TOWN & COUNTRY PLANNING (ENVIRONMENTAL IMPACT ASSESMENT)(ENGLAND & WALES) REGULATIONS 1999

REGULATION 19 - SCHEDULE OF FURTHER INFORMATION REQUIRED

BROADWATER ROAD WEST ENVIRONMENTAL STATEMENT, SEPTEMBER 2010

Response to Schedule

03. EAST ELEVATION

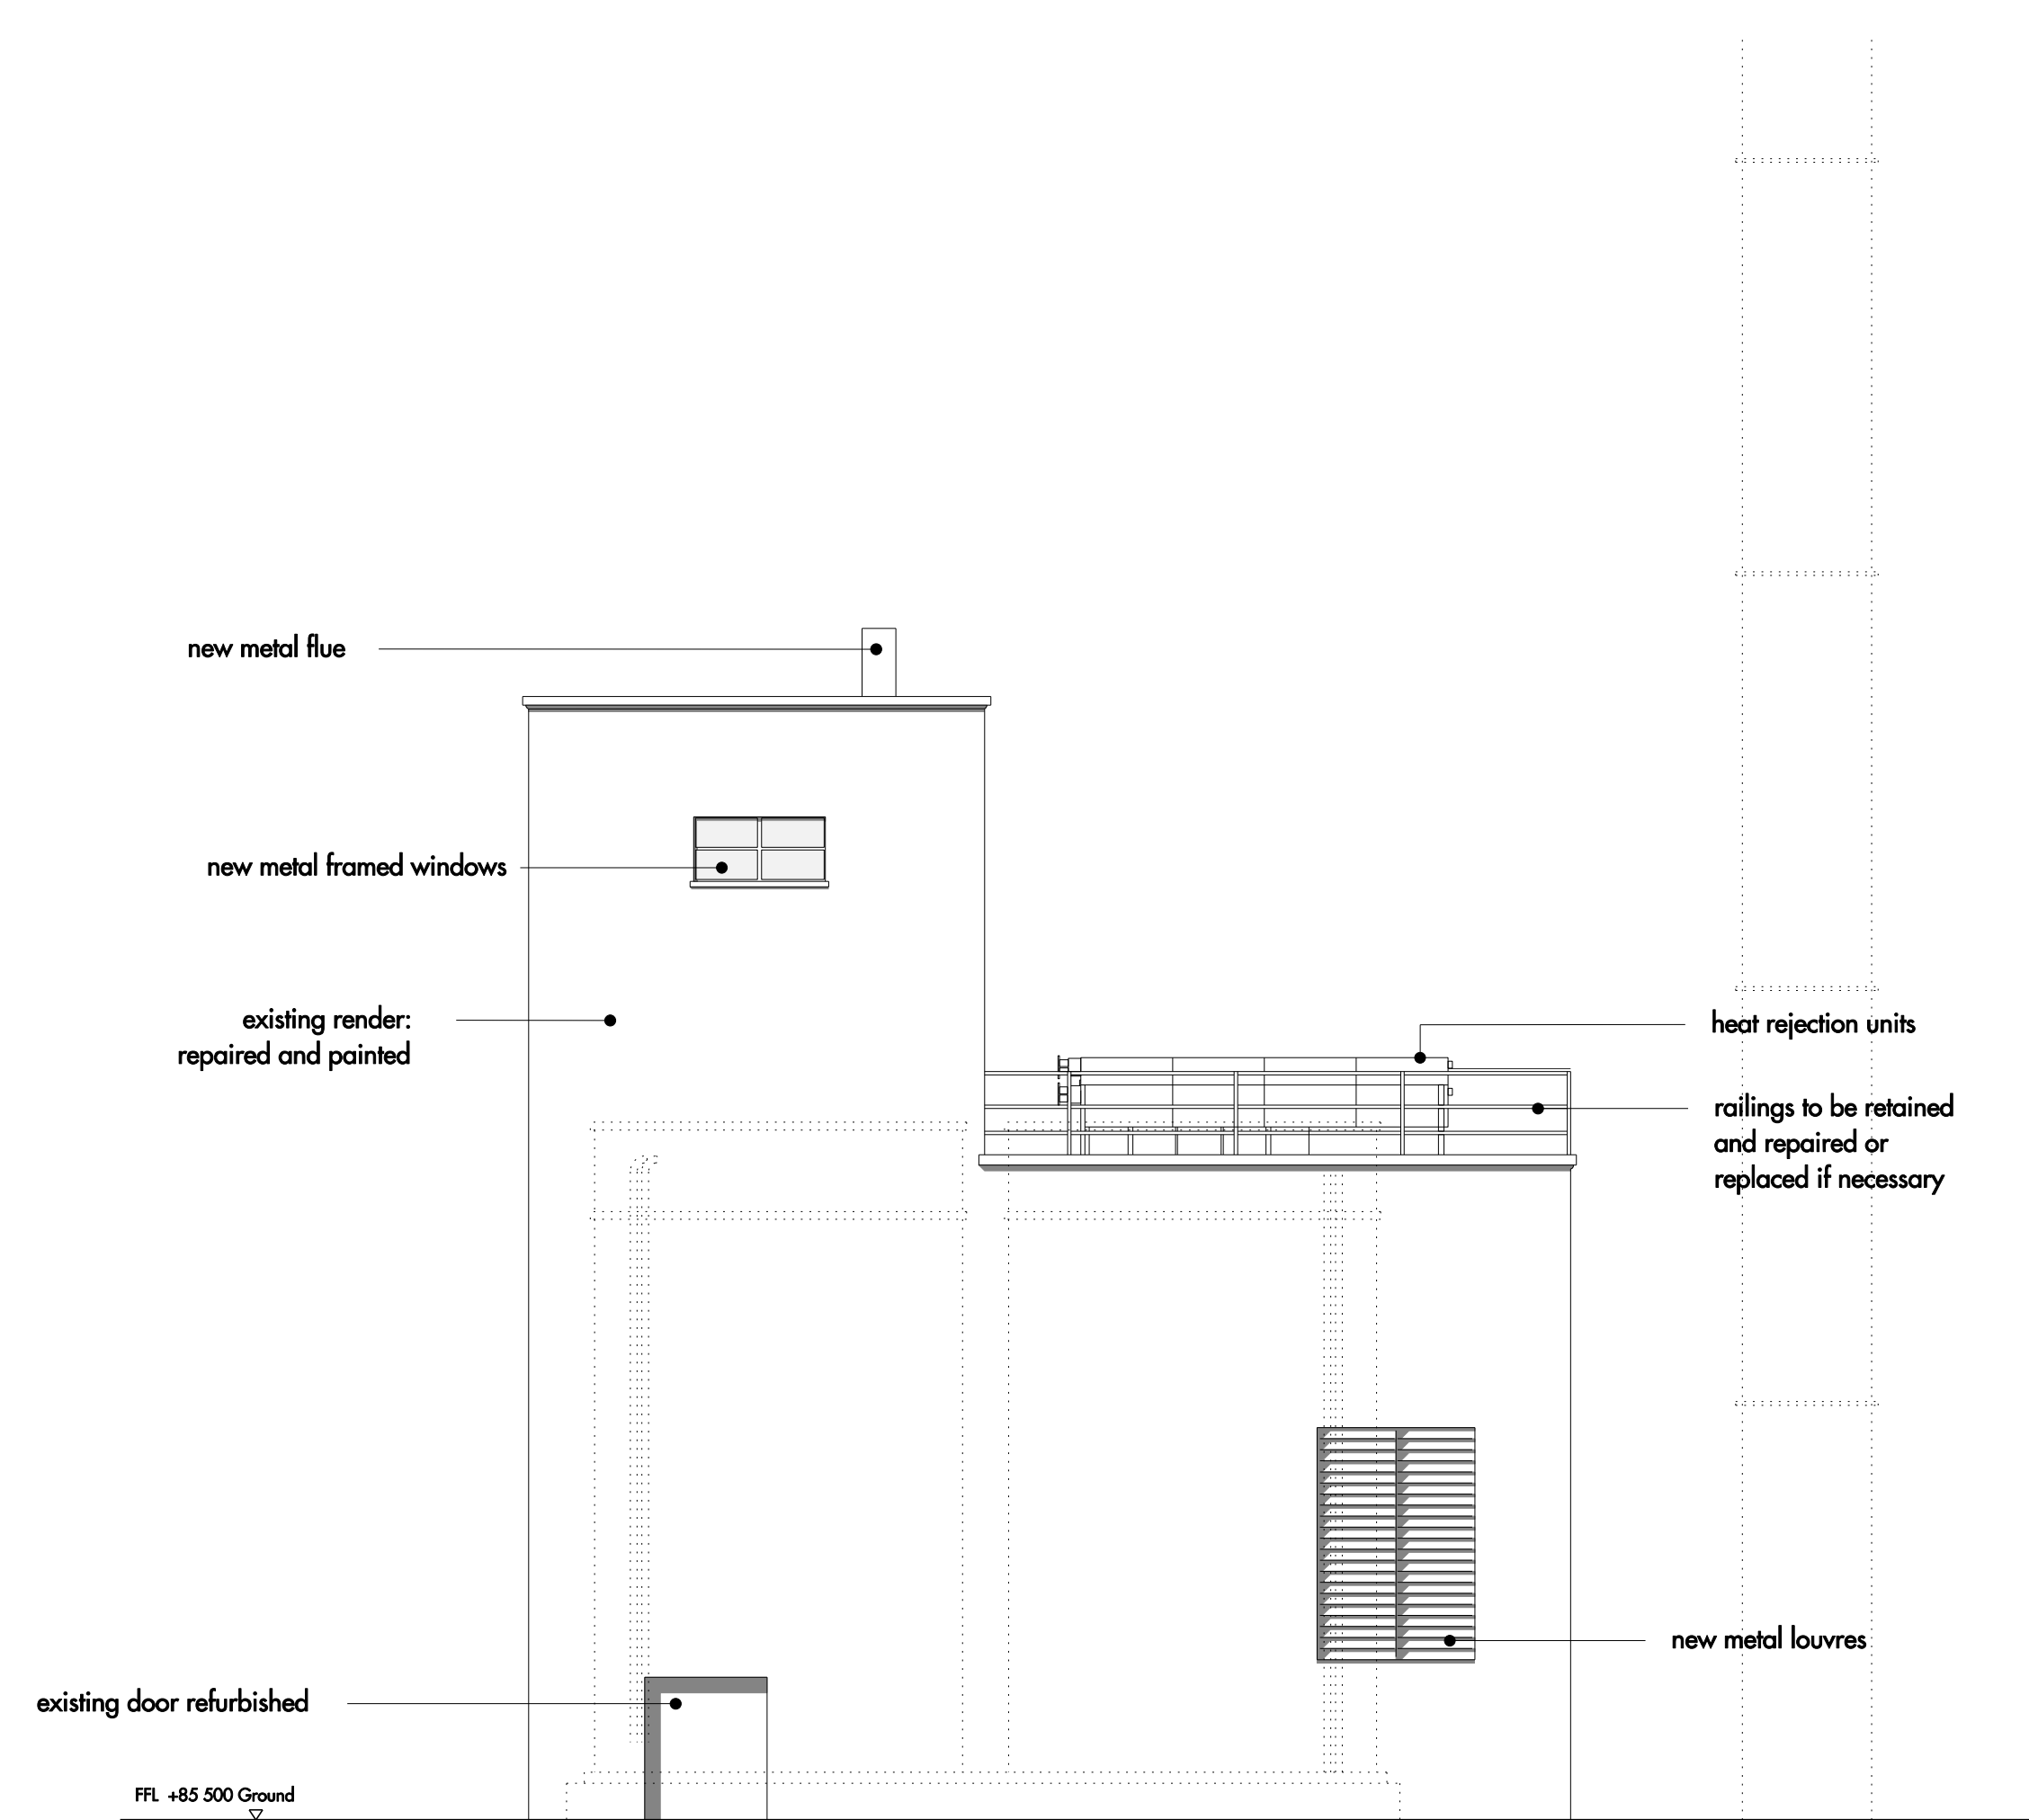
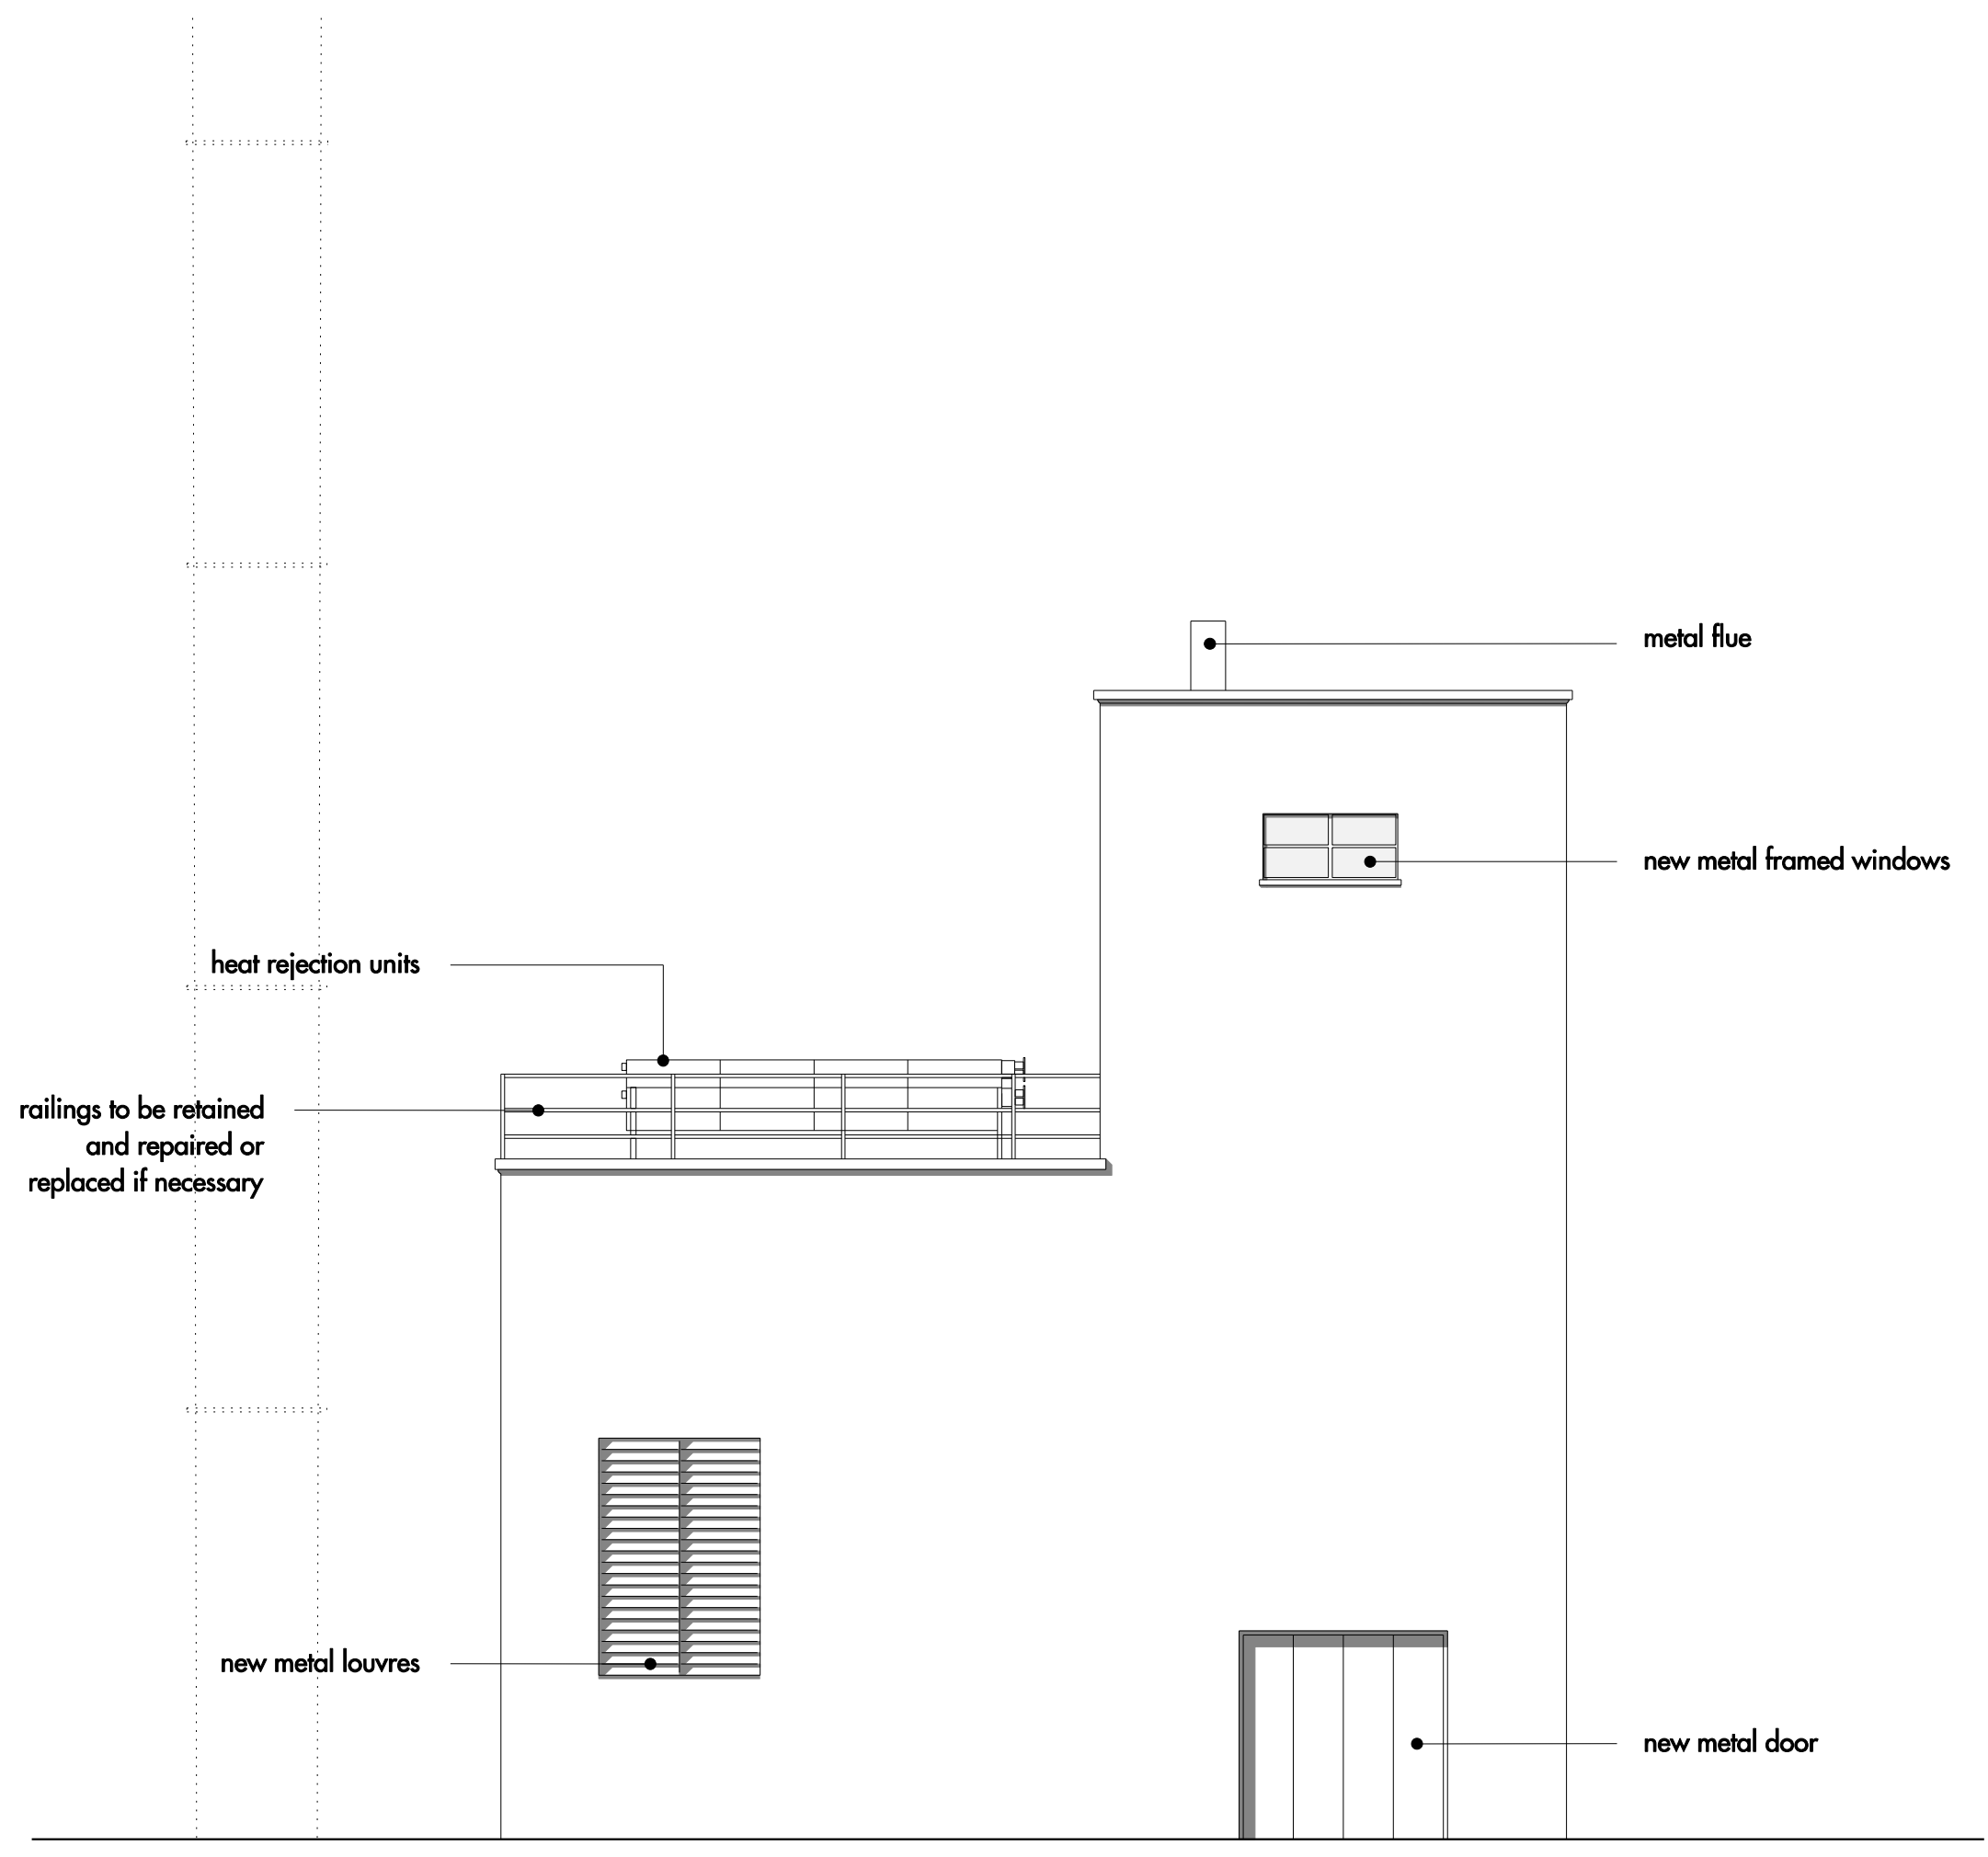
- 2.1 Confirmation is needed on the fuel type proposed for the CHP, and whether or not the CHP will serve the whole development. Confirmation is also needed as to whether the existing building and stack proposed to be re-used for this purpose will be adequate to house all of the plant required. Confirmation should be provided of the air quality, noise and visual impacts that will result from the CHP, as nearby residential units and other uses which may be adversely affected by the CHP lie within the area of the detailed application.

The energy strategy and statement (Part C Appendix C) has been updated in conjunction with the scheme description to make it clear that the existing boiler house is to be used to house the energy centre for both detailed and outline application

areas, and that the existing stack will be re-used, to incorporate new internal gas flues for the gas-fired CHP plant. The energy centre is fully considered the environmental topic impact assessments
